Our Ref NCA/8/2019

27 Apr 2020

COUNCIL SUBMISSION
SSD 10383 – 2 Darcy Road, Westmead
Westmead Catholic Community Education Campus

PIT 03\03 - RAINWATER TANK AND
WATER QUALITY CHAMBER PLAN

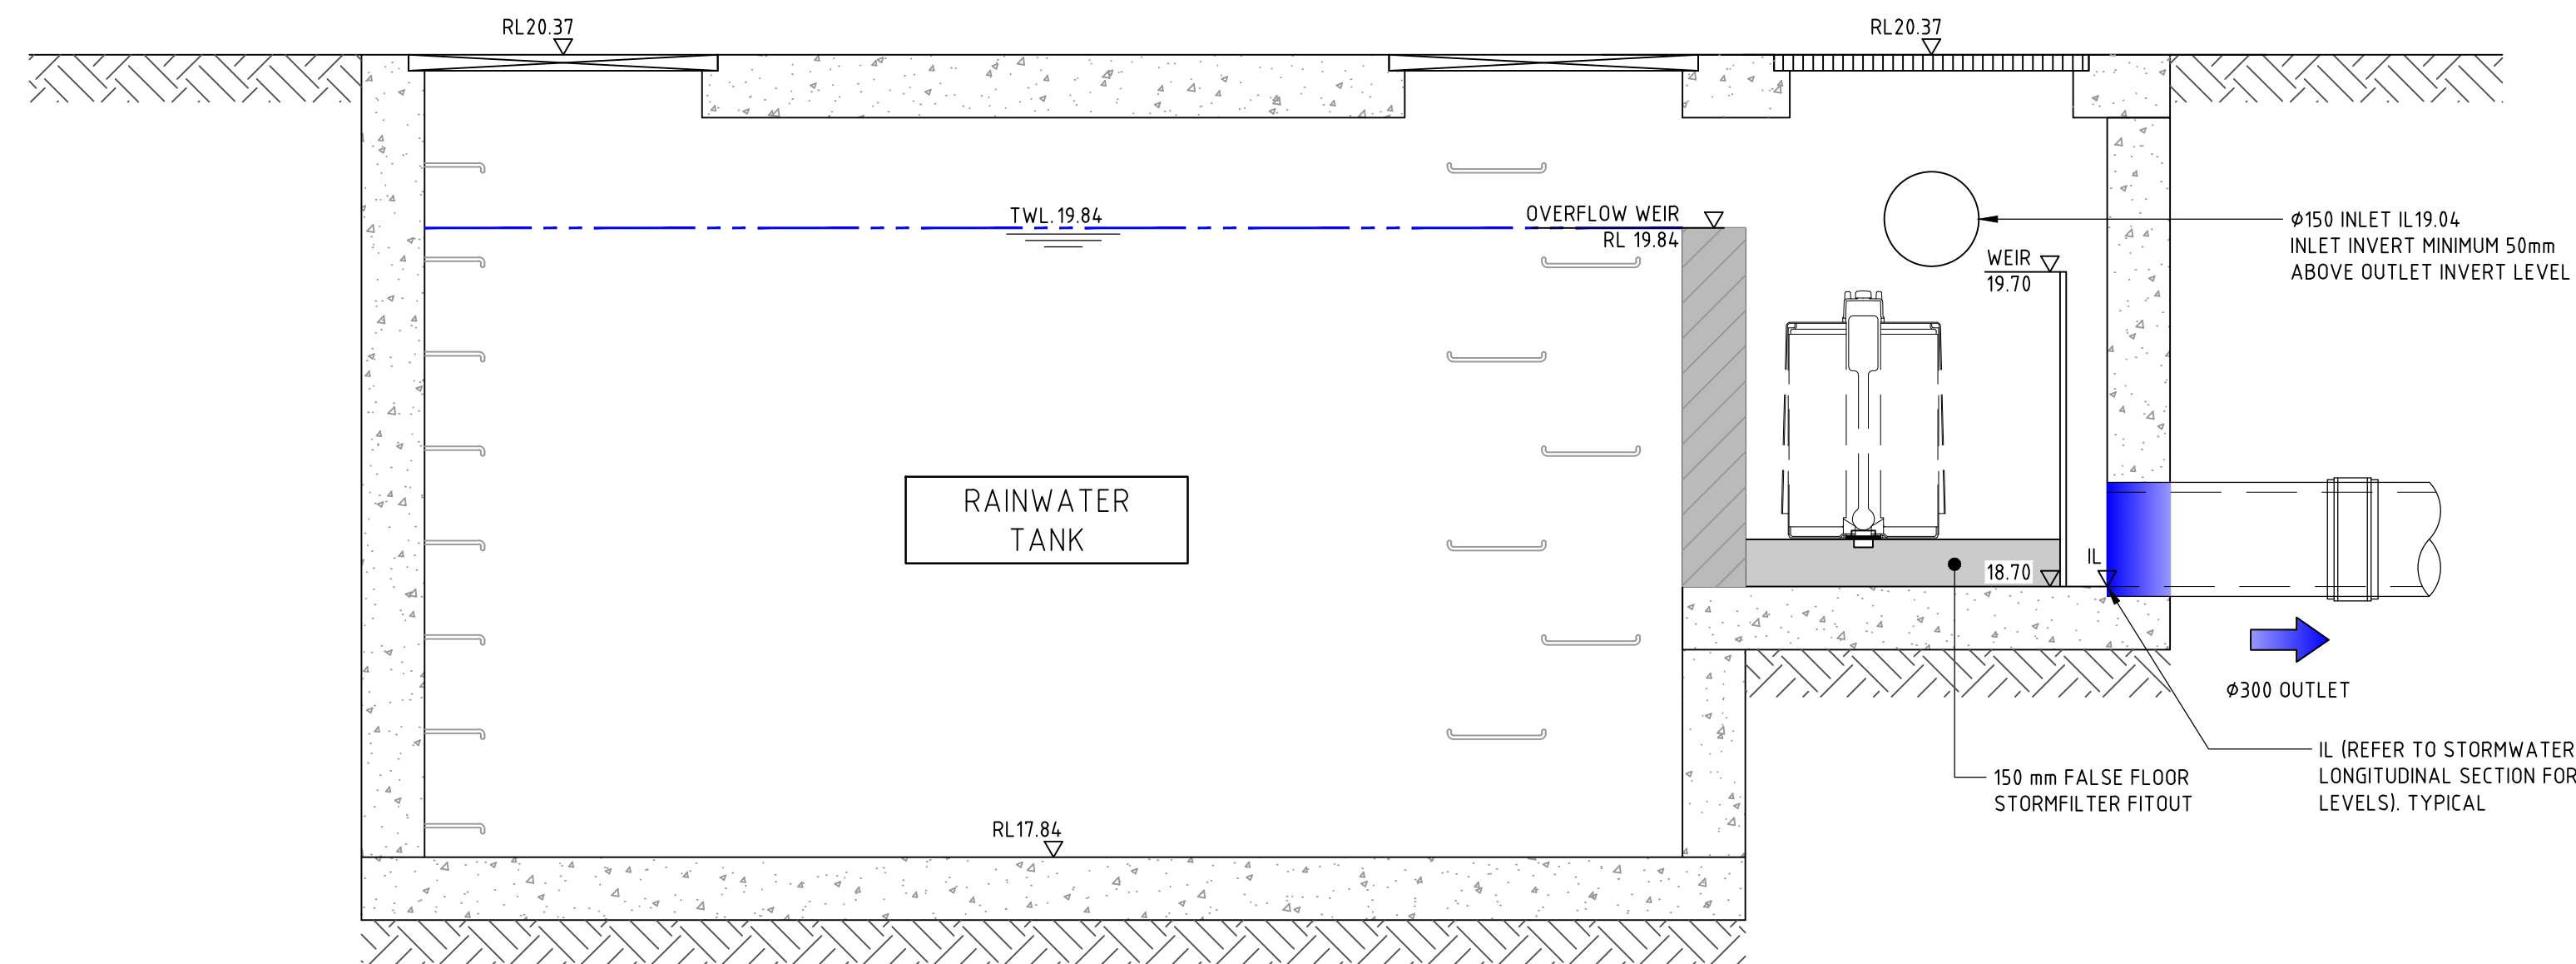
Council strongly prefers integration of the WSUD systems into the landscape with design elements such as deep soil, bio-swales, wetlands and the like in preference to 'end-of-pipe' proprietary water treatment devices. From the information provided it would appear

that the Applicant has chosen tank containing 'Stormfilter' proprietary devices as the only approach to water quality management. (Water Management Plan and Civil Drawings). Given the size of the site, there is sufficient opportunity to design the landscape to incorporate WSUD, and this should be pursued.
